Re: Aztec Special Education Facility
Request for Certificate of Occupancy- Transportation Development
Architect's Stamp dated 09-22-15 (H20-D033)
Certification dated 01-12-17

CITY OF ALBUQUERQUE

Re: Aztec Special Education Facility
Request for Certificate of Occupancy- Transportation Development
Architect's Stamp dated 09-22-15 (H20-D033)
Certification dated 01-12-17

Drawing file: H20D033 / AS-101 Enlarged Site Plan.pdf

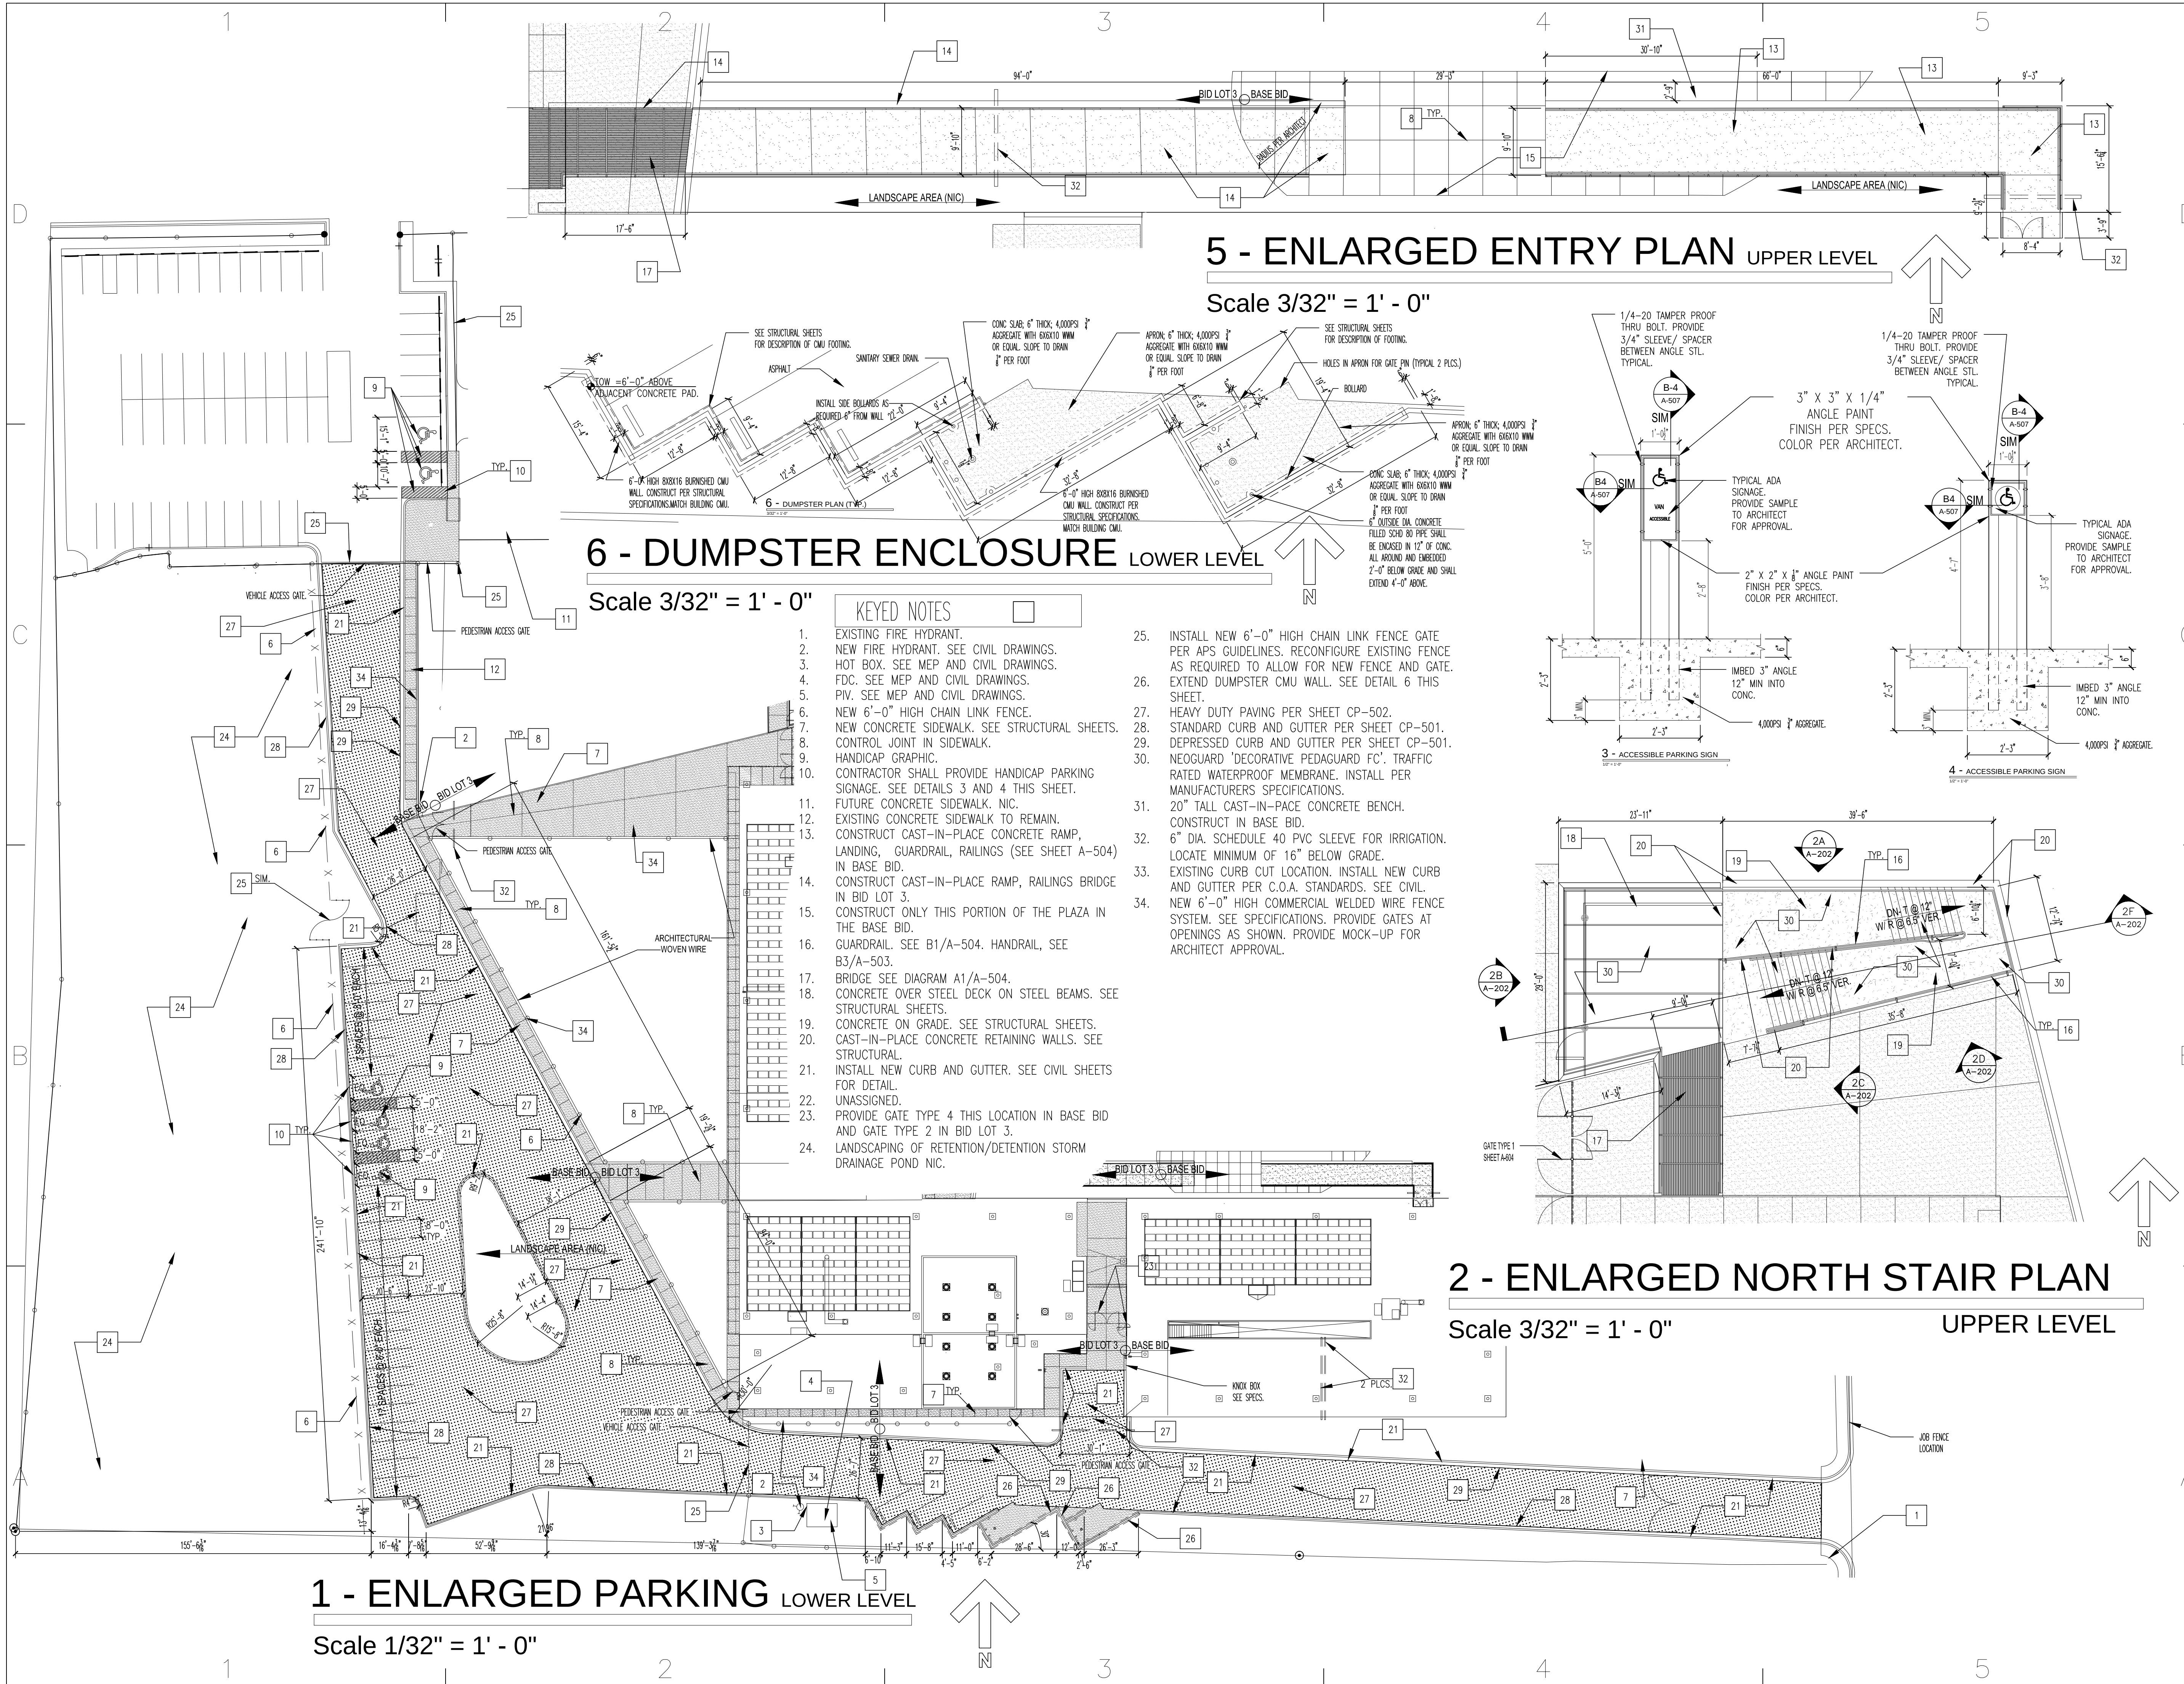
- The site had construction equipment, material, and debris throughout the parking lot. The site should be safe and ready for use by the general public at CO.
- The ADA access ramp on exhibit ASI-042 did not have the prefab detection pad or detectable warning surface as indicated on the plans.
- Motorcycle space should be labeled.
